# Derrygreenagh Power Submission

**File No:**  
319023 (SID Application)

**Applicant**  
Board na Mona  
(Derrygreenagh Power)

**Description**  
Combined Cycle Gas Turbine and Open Cycle Gas Turbine Thermal Power Plant, Electricity Grid Connection including 2 no. substations, and associated buildings, plant, site works, service and ancillary development.

NOTES:

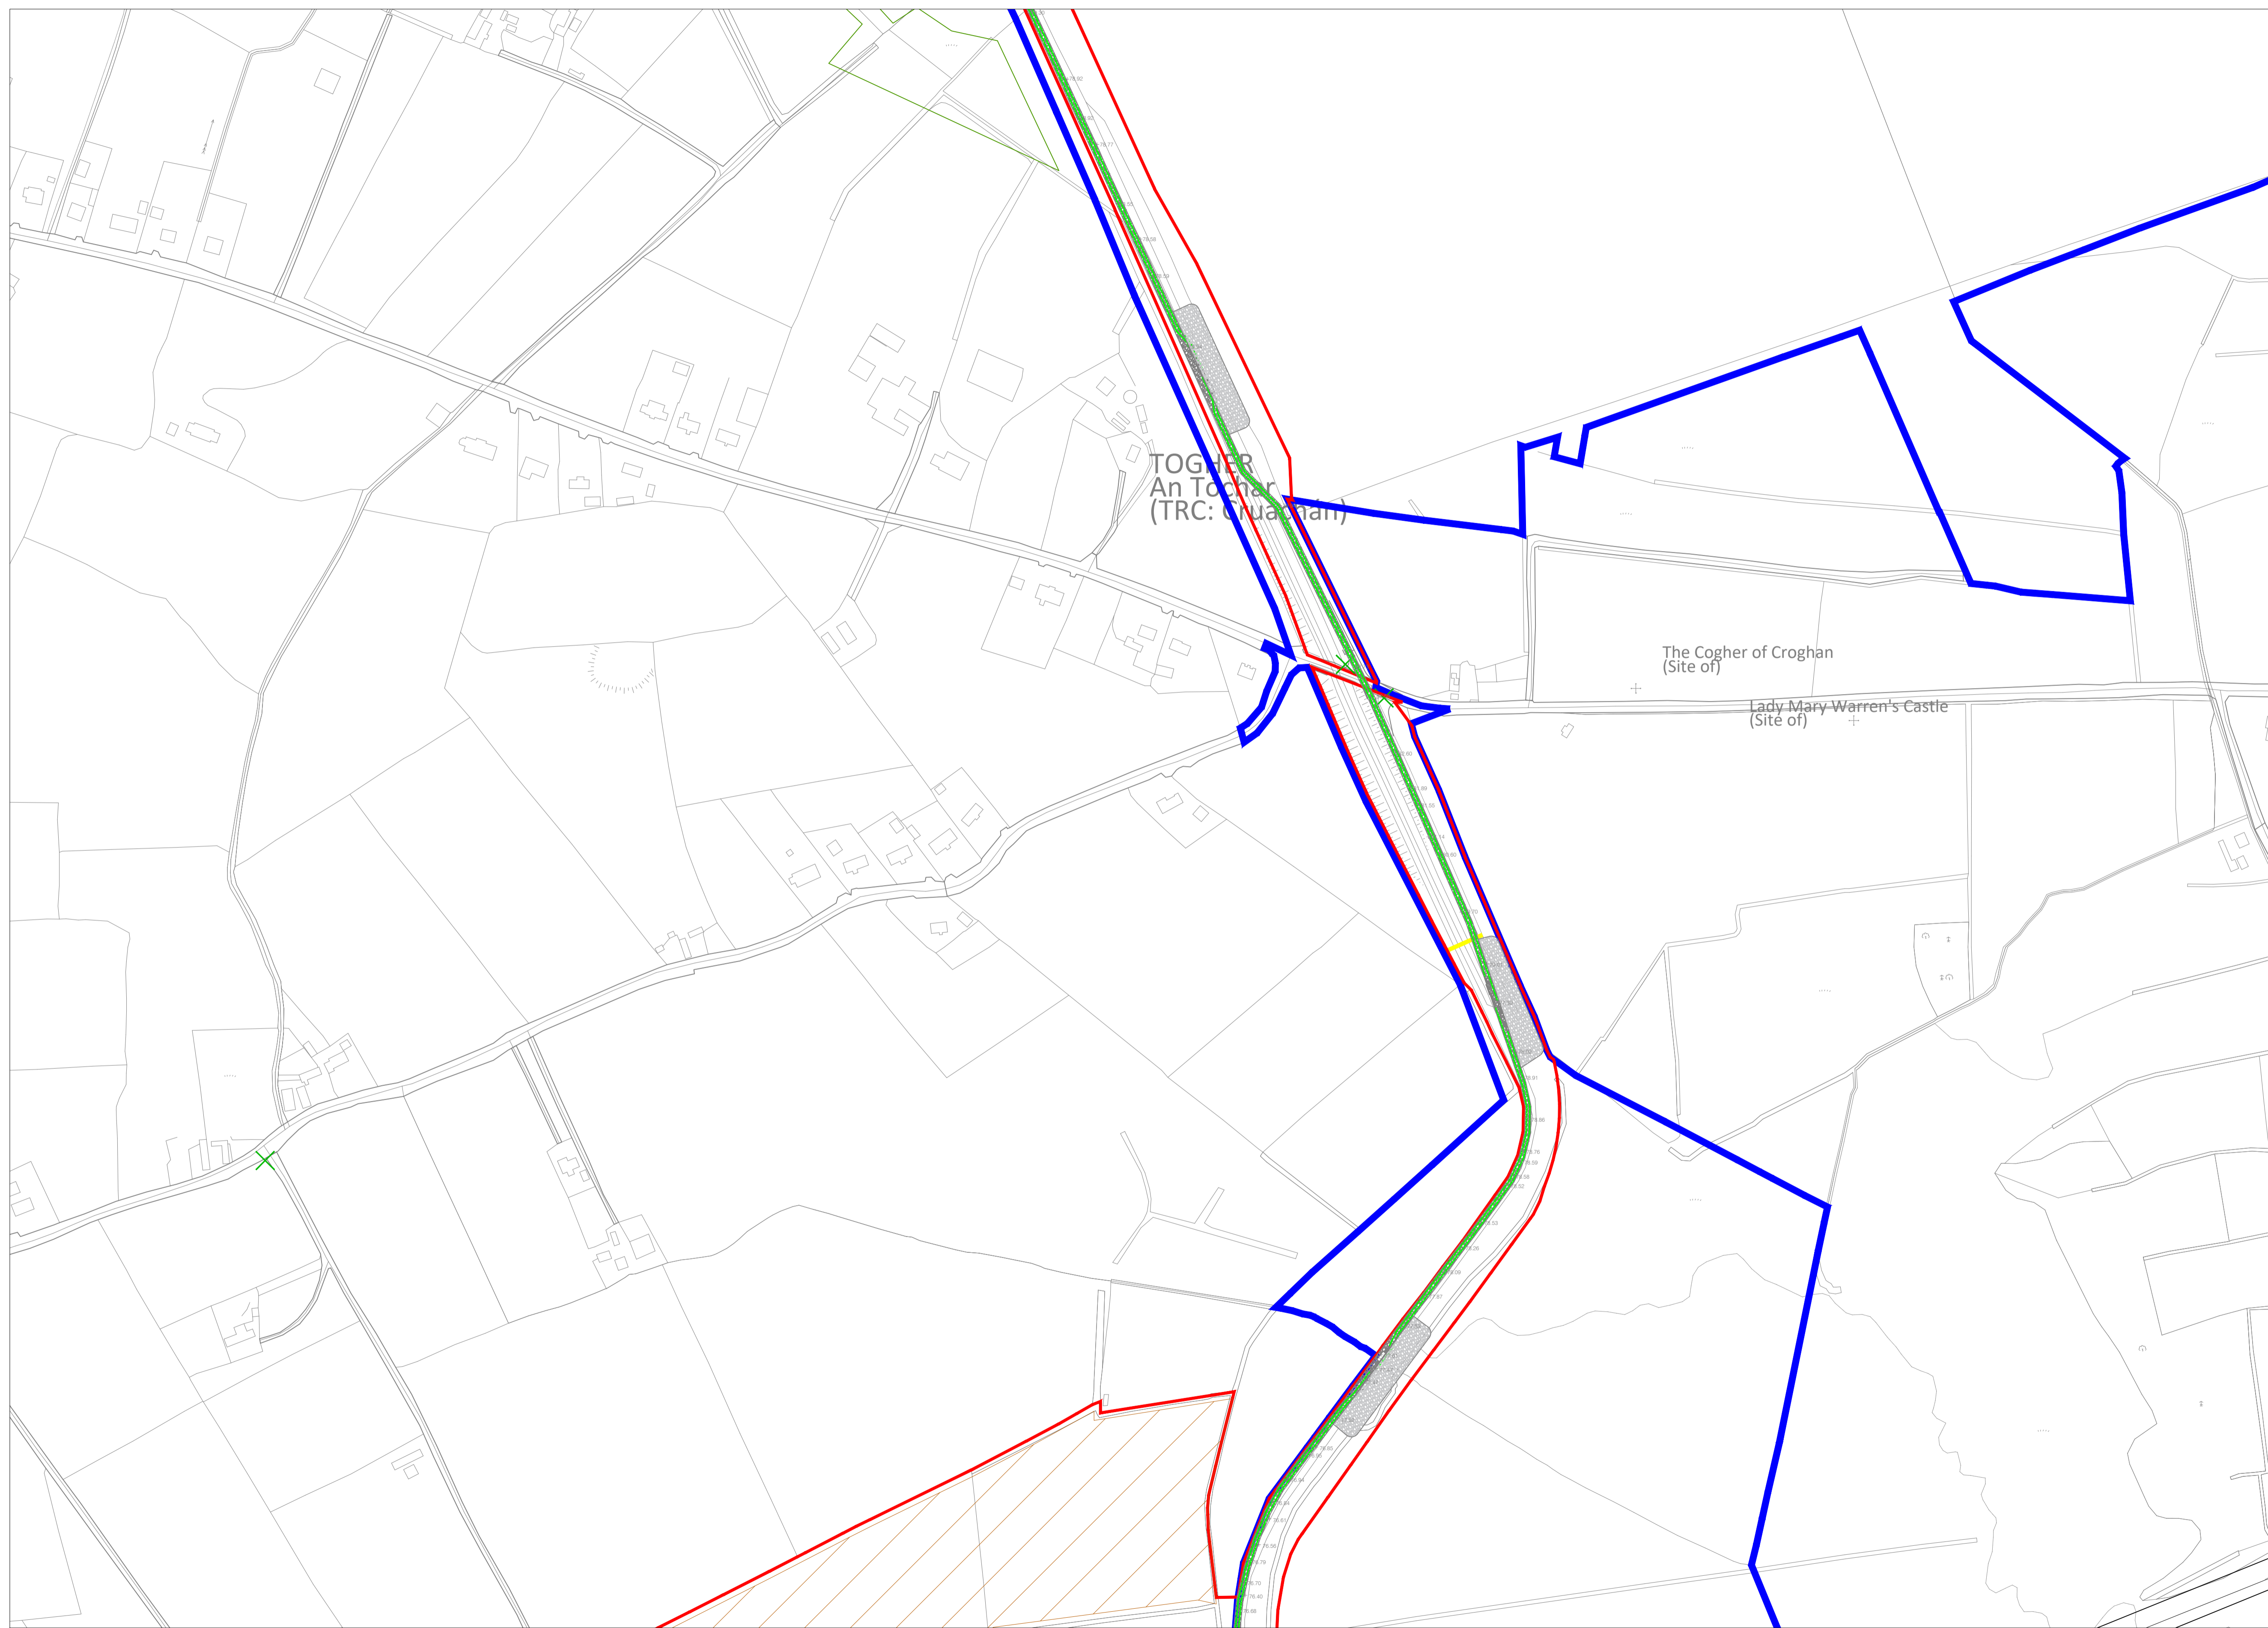
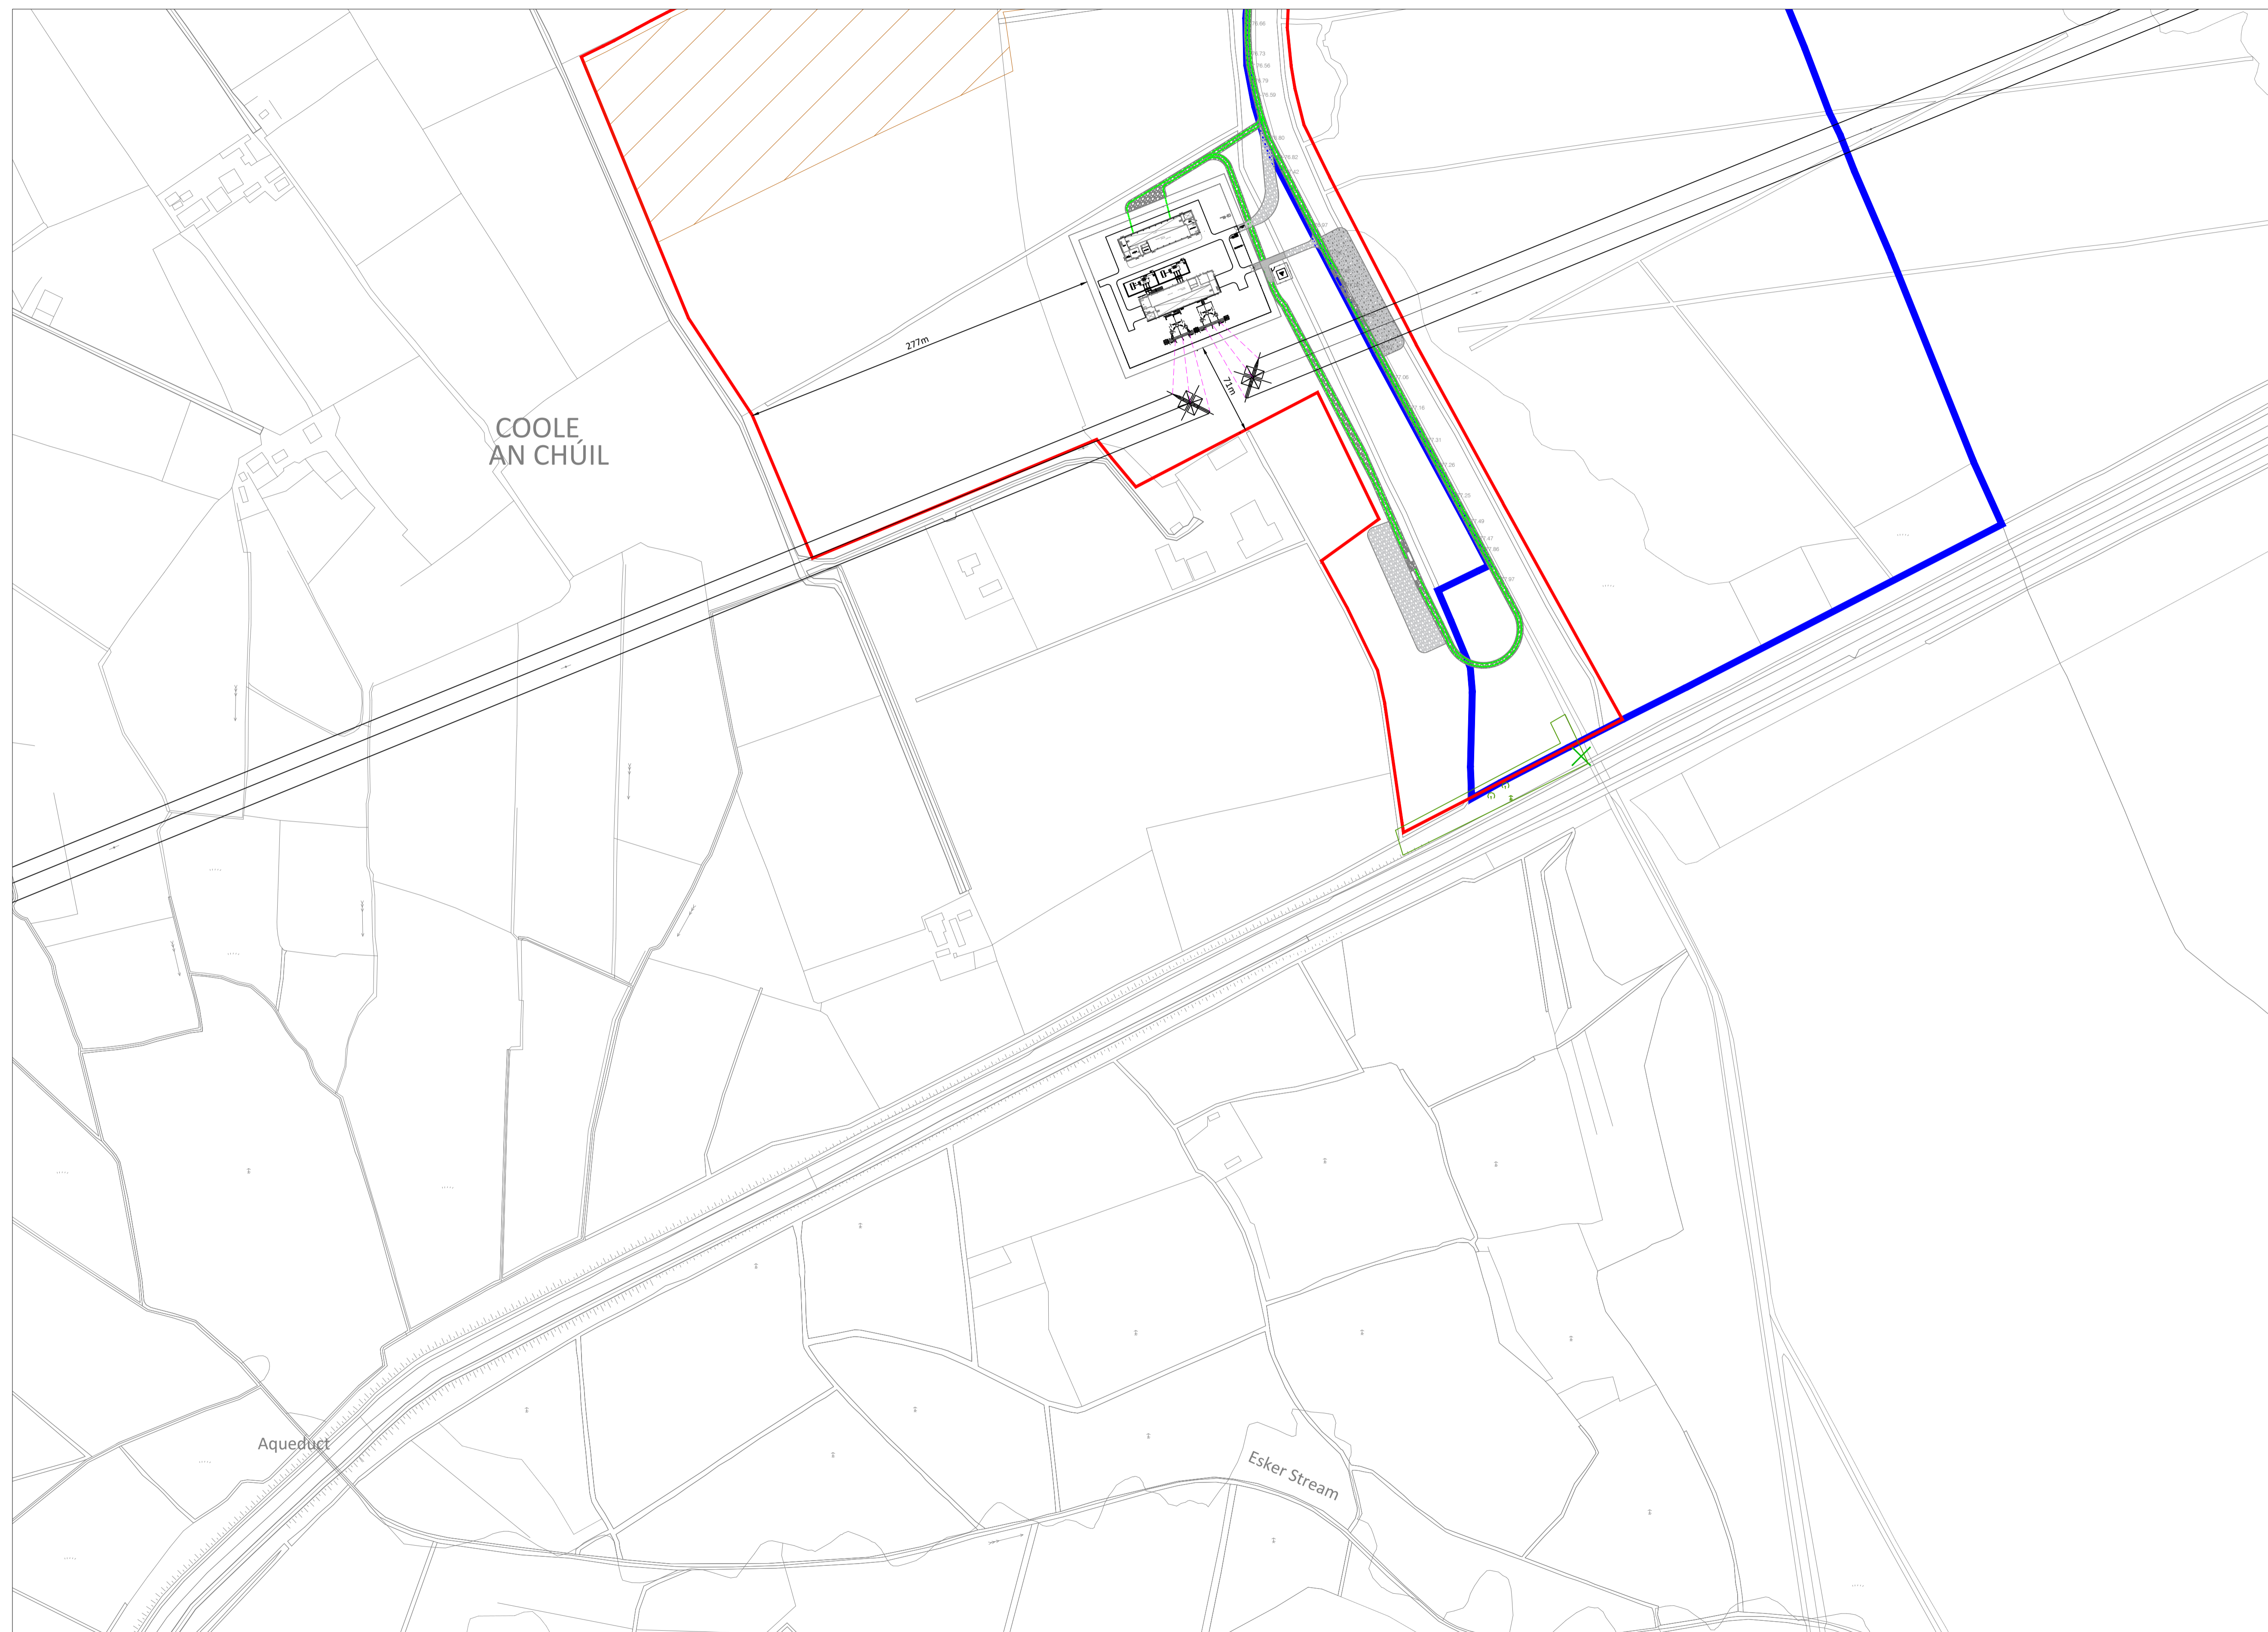
1. The cabling connecting this development to the substation be located entirely underground with no **overhead wires/pylons permitted**.

The proposed cable way will have a major visual impact on the surrounding countryside. This imposition can be overcome by undergrounding the entire cable way from Derrygreenagh to Tubberdaly.

The red outline below shows that the development boundaries of this development extend beyond the site of the Power Station building itself. There are no houses located within 1km of the Power Station Building, but homes located next to cable routes and substations should qualify for a near neighbour payment as they are equally as affected.
